APPROVED
 Limited building only review
 Permit holder responsible for
 full compliance with the code

A frame built on stilts
 20x30

sheet no.
S1 of **S1**
plan no.
2312-15

Ron Sherpinkas
274 Valerie Lane

sheet no.
S1 of **S1**
plan no.
2312-15

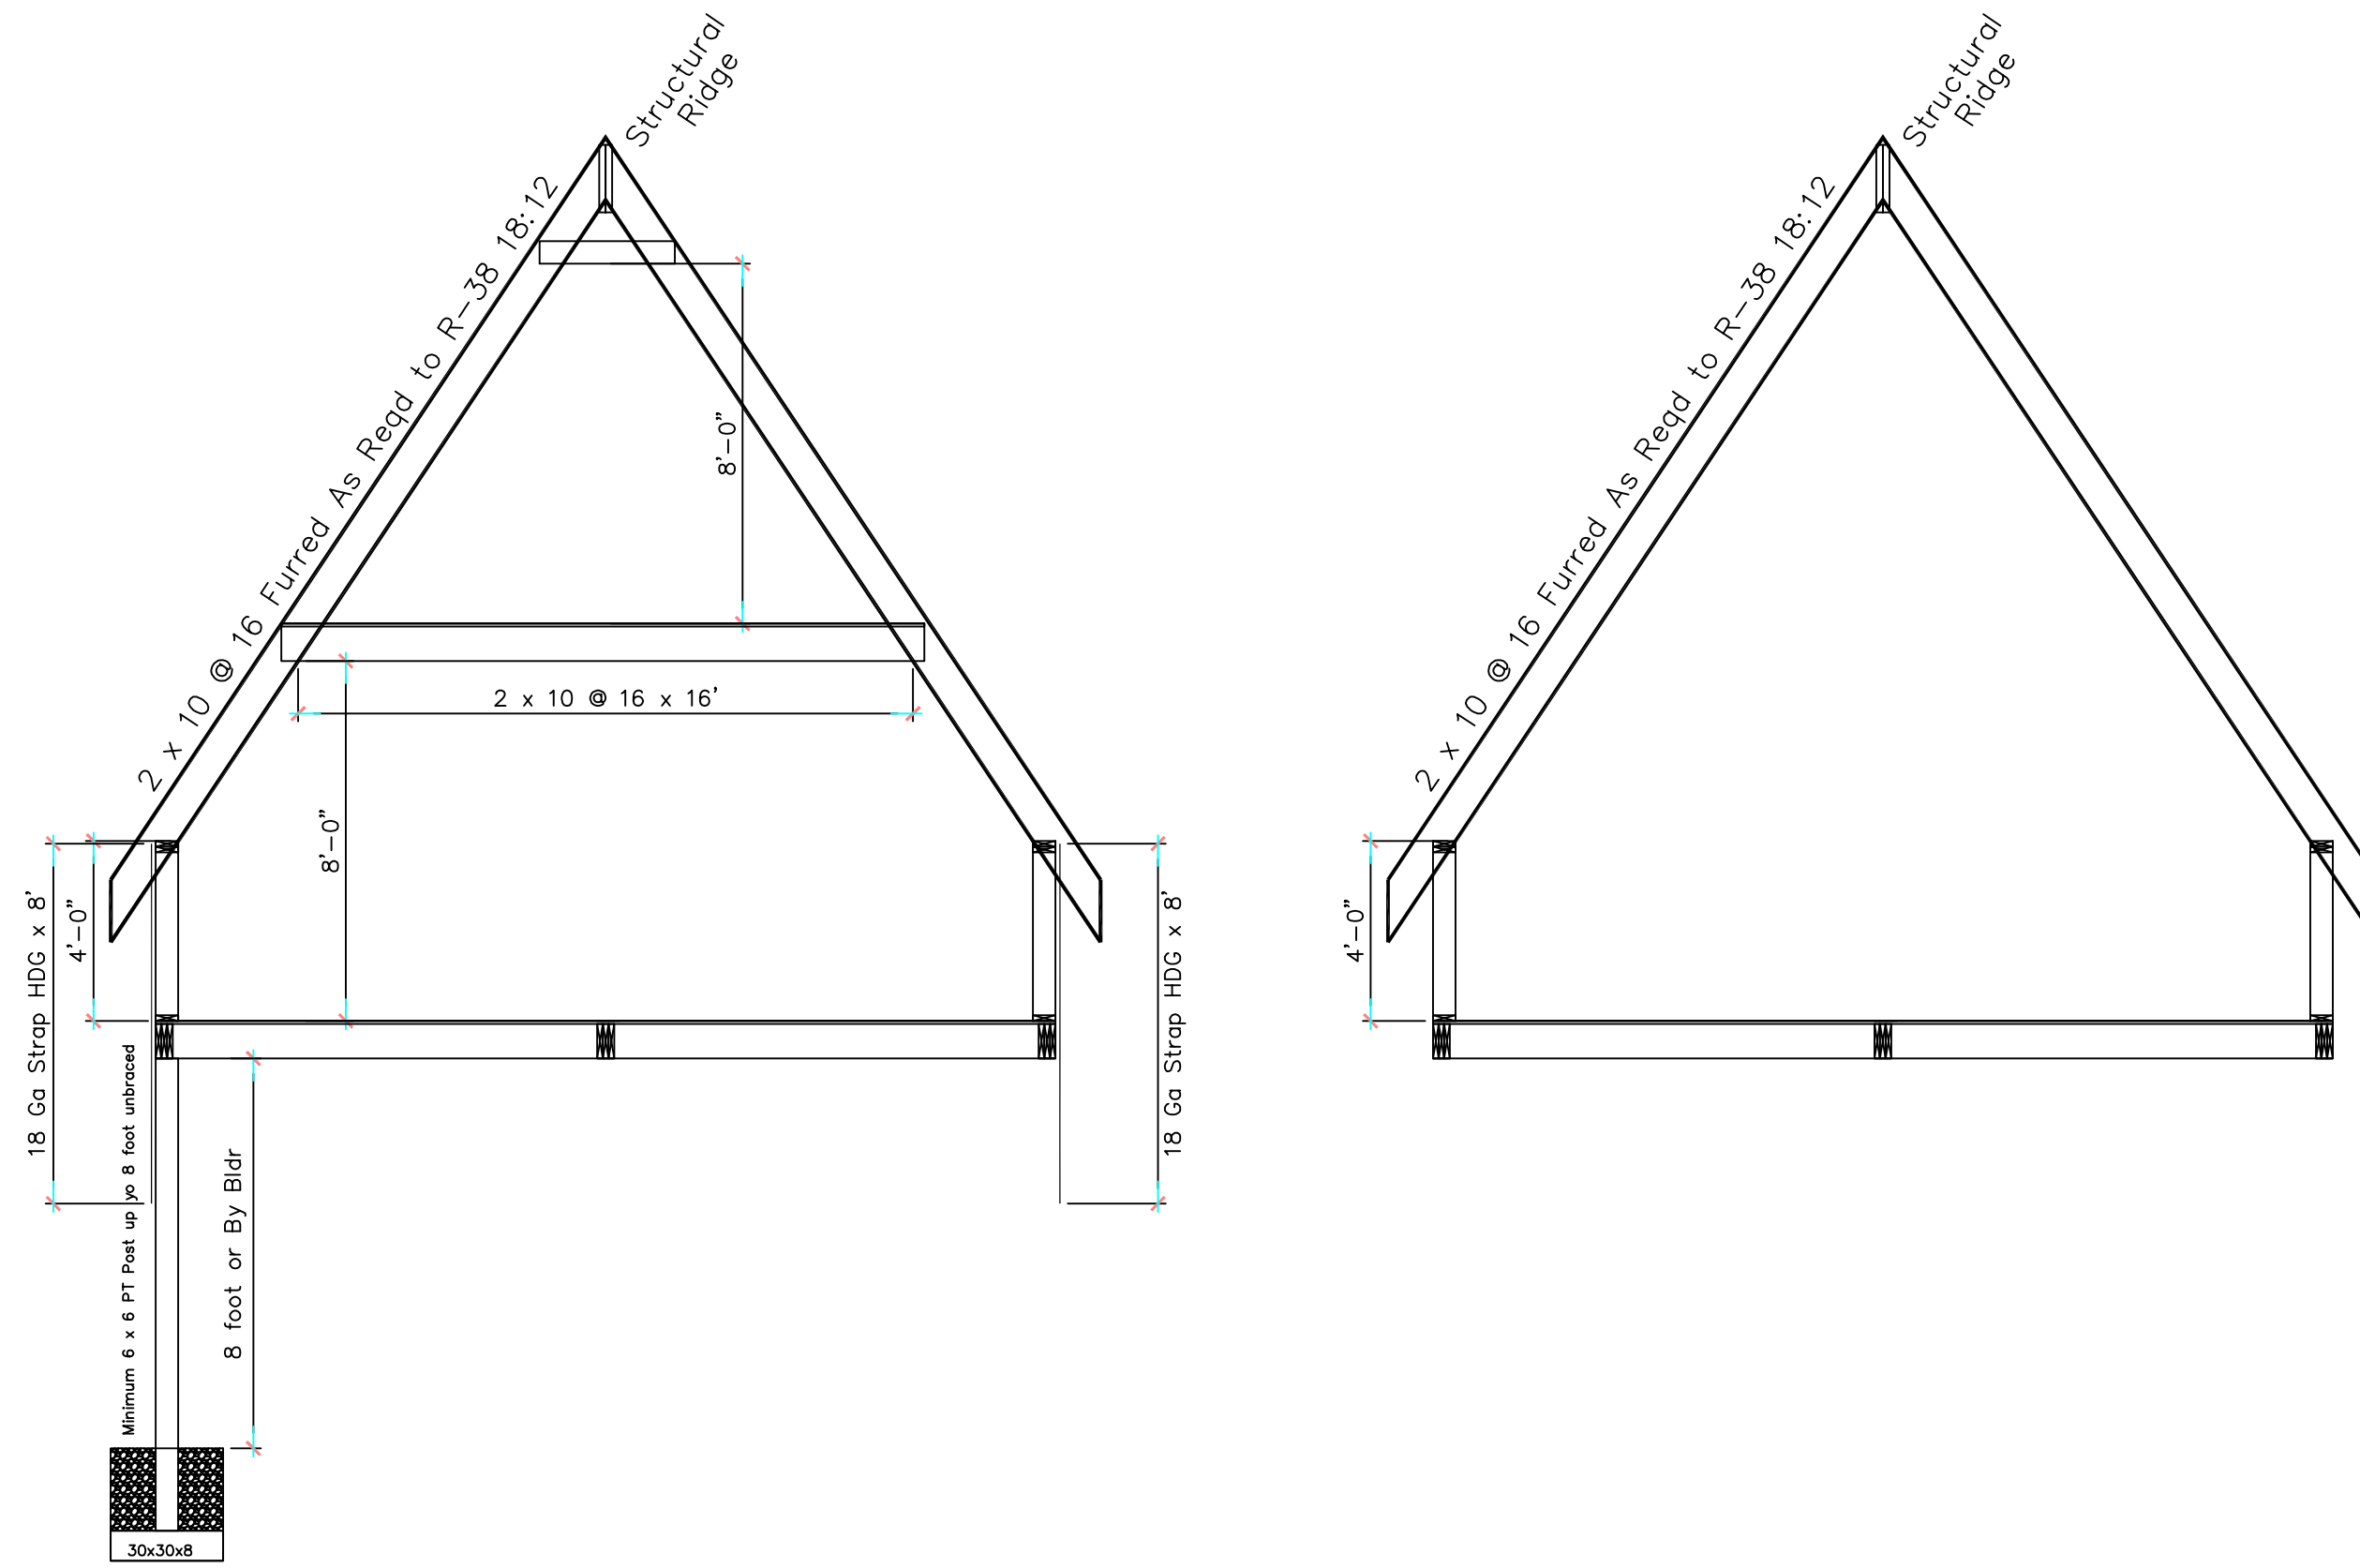
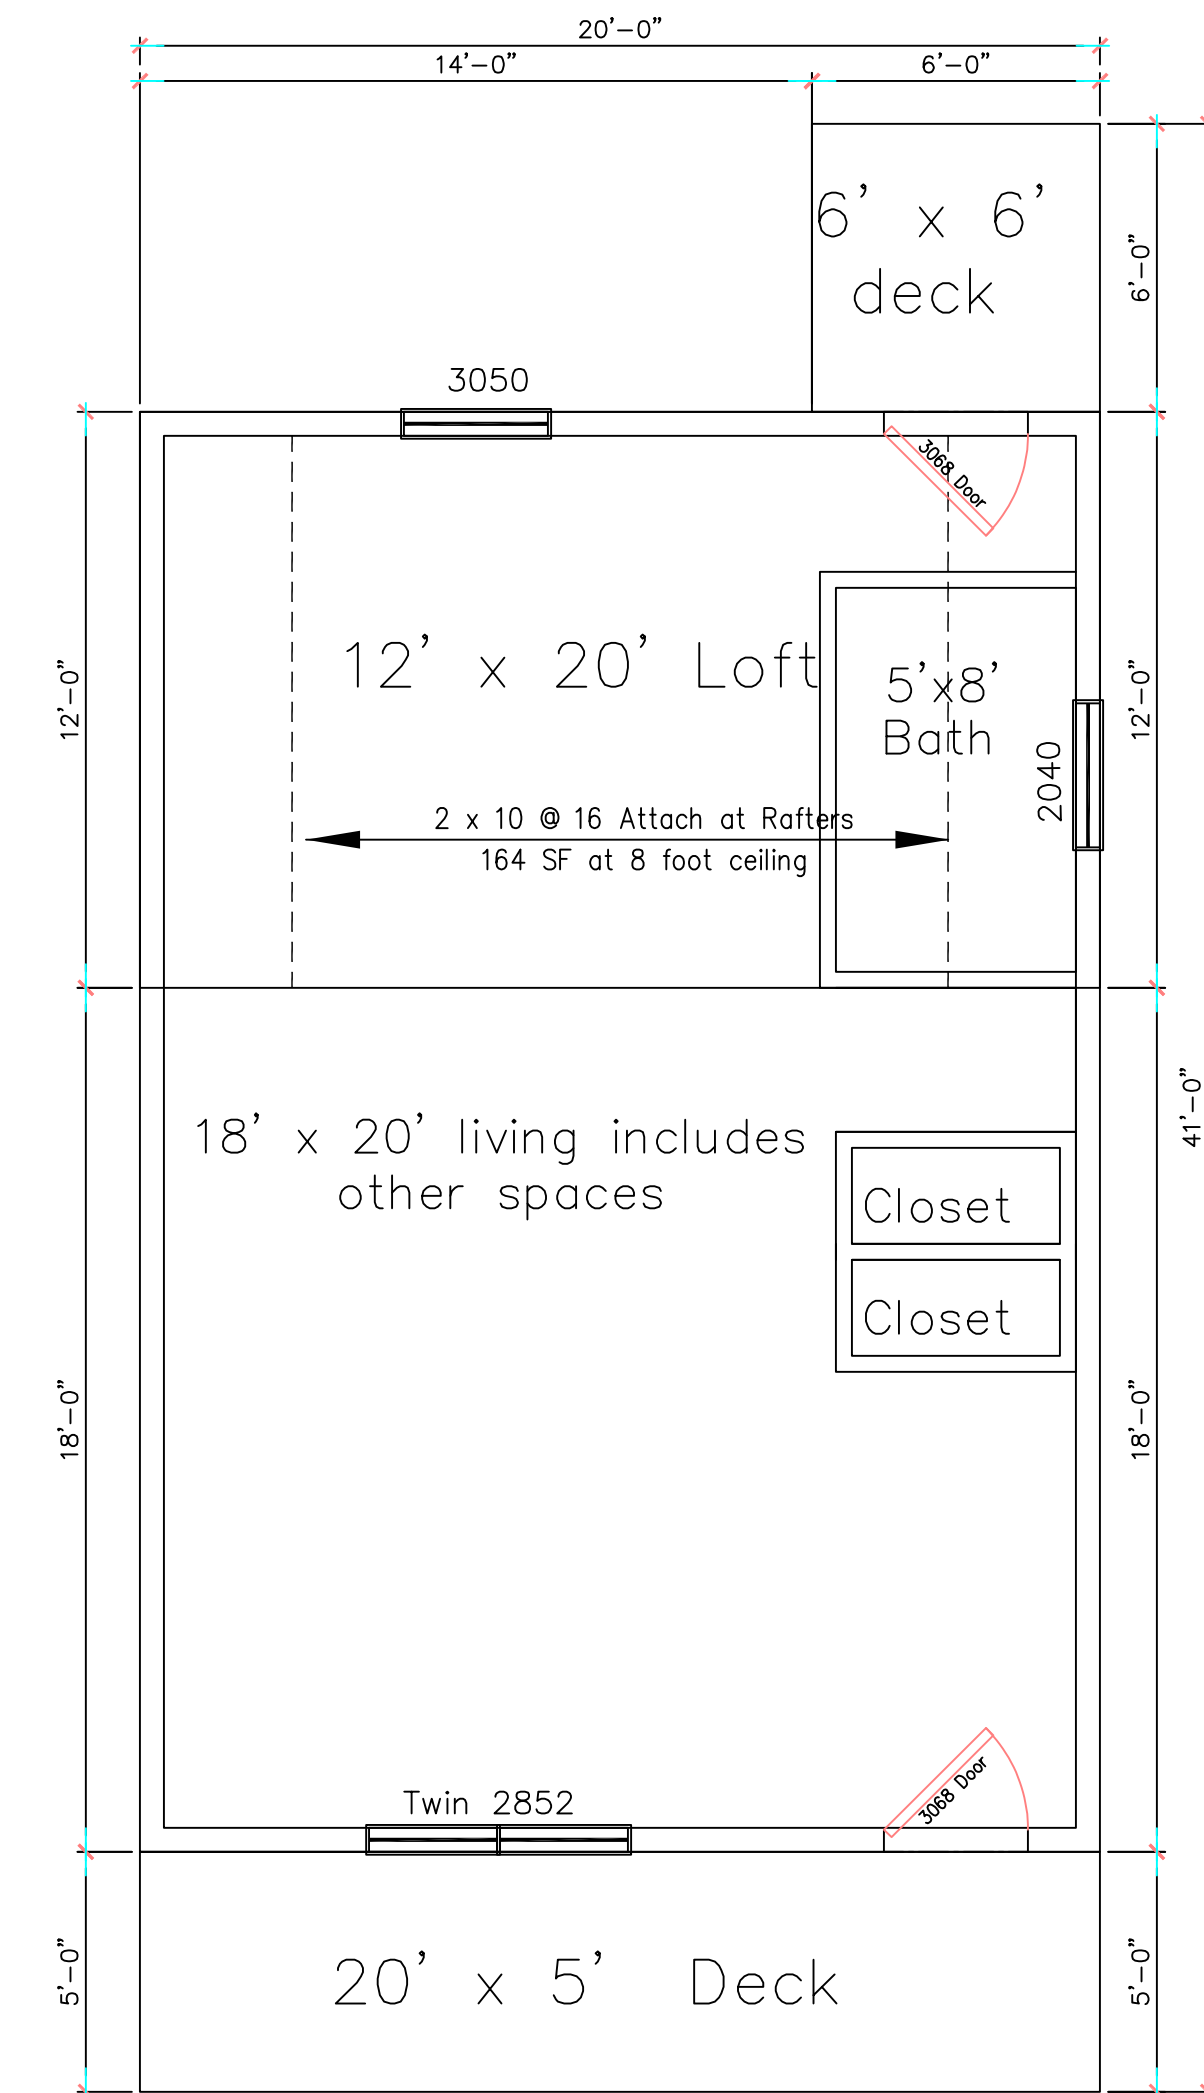
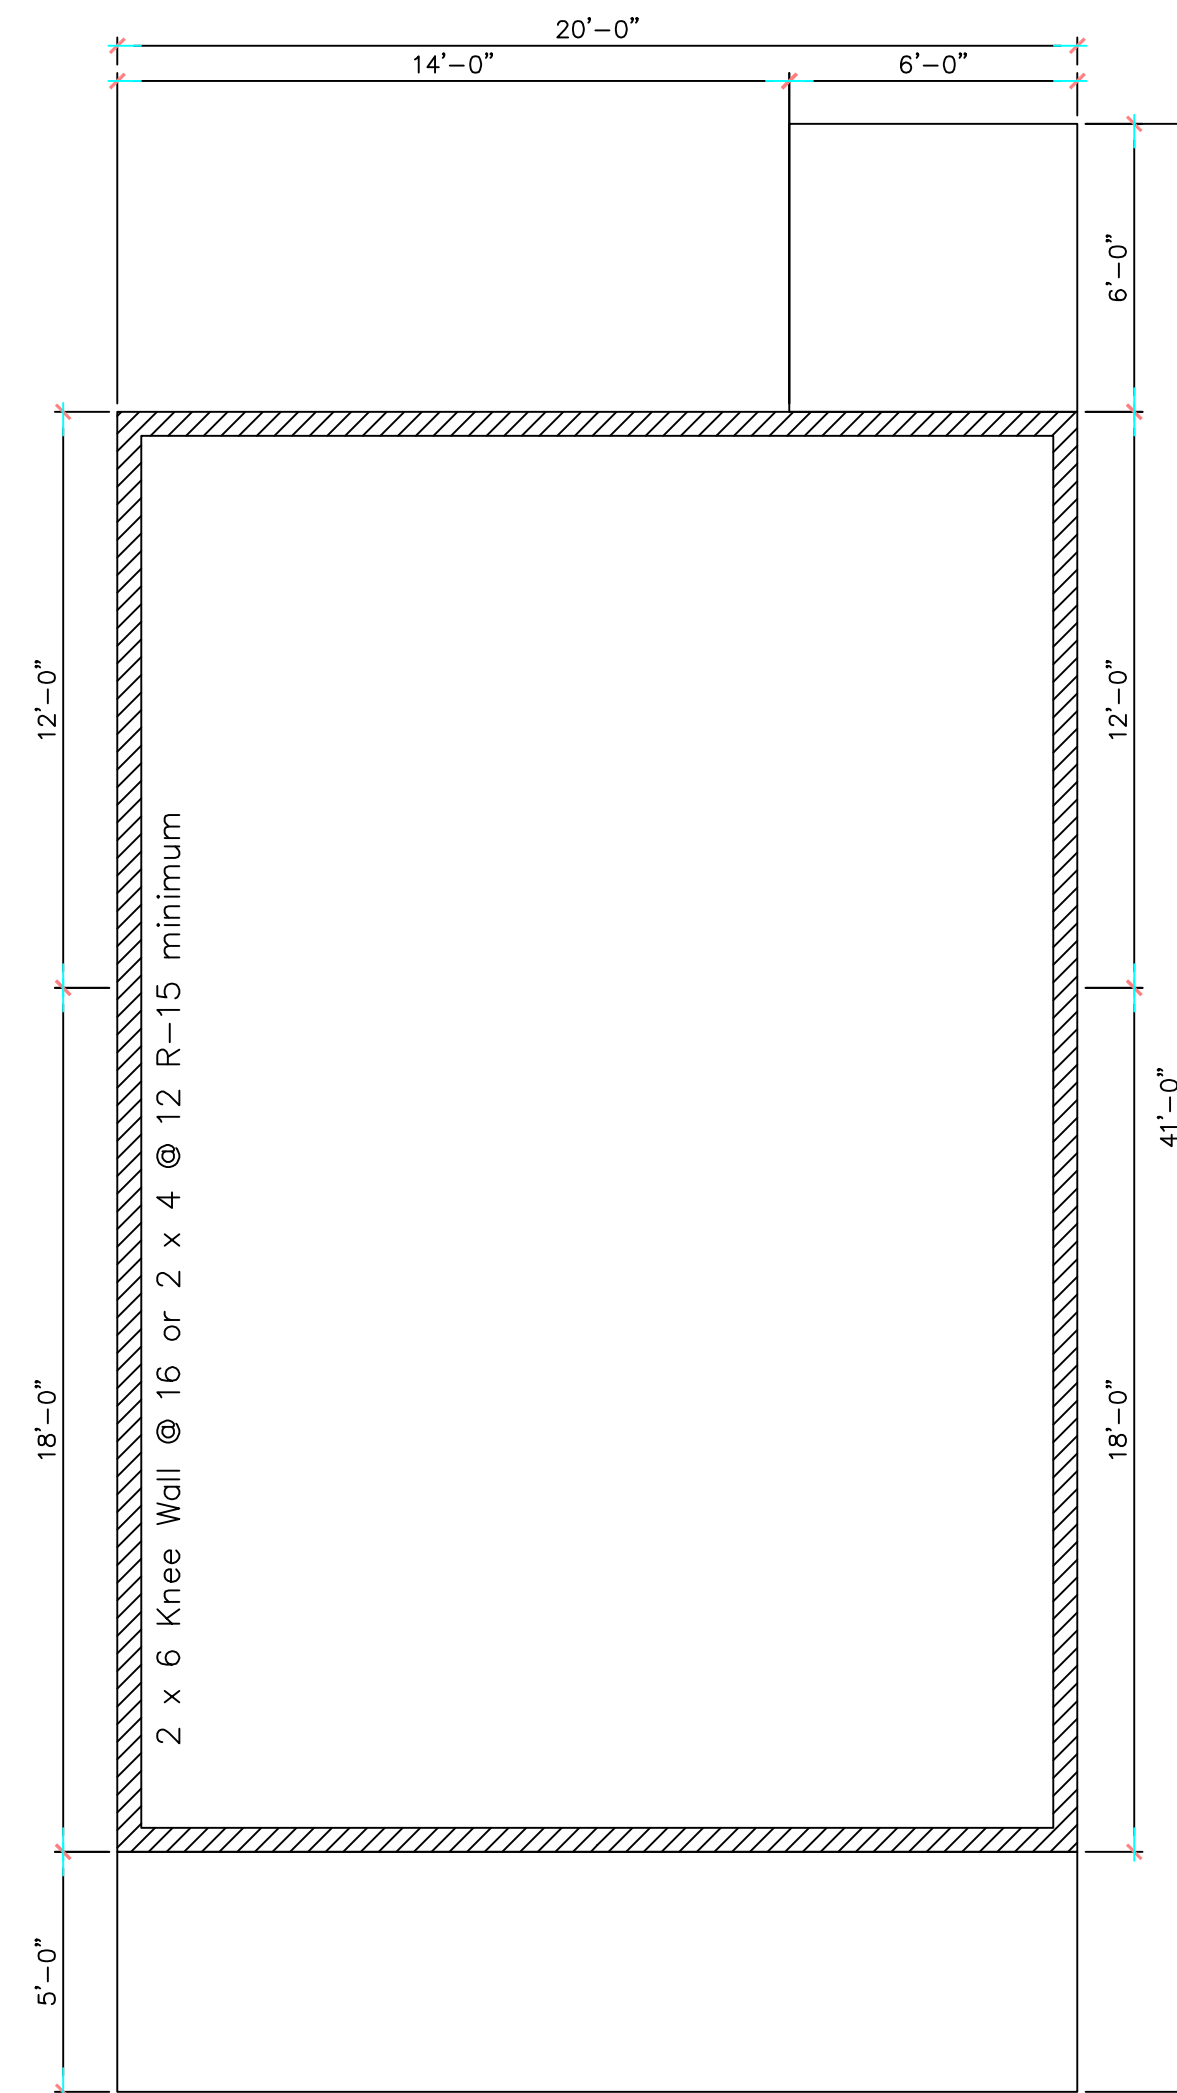
See all notes. Code
 compliant egress window
 required in loft. All egress
 windows shall meet 2nd
 floor requirements
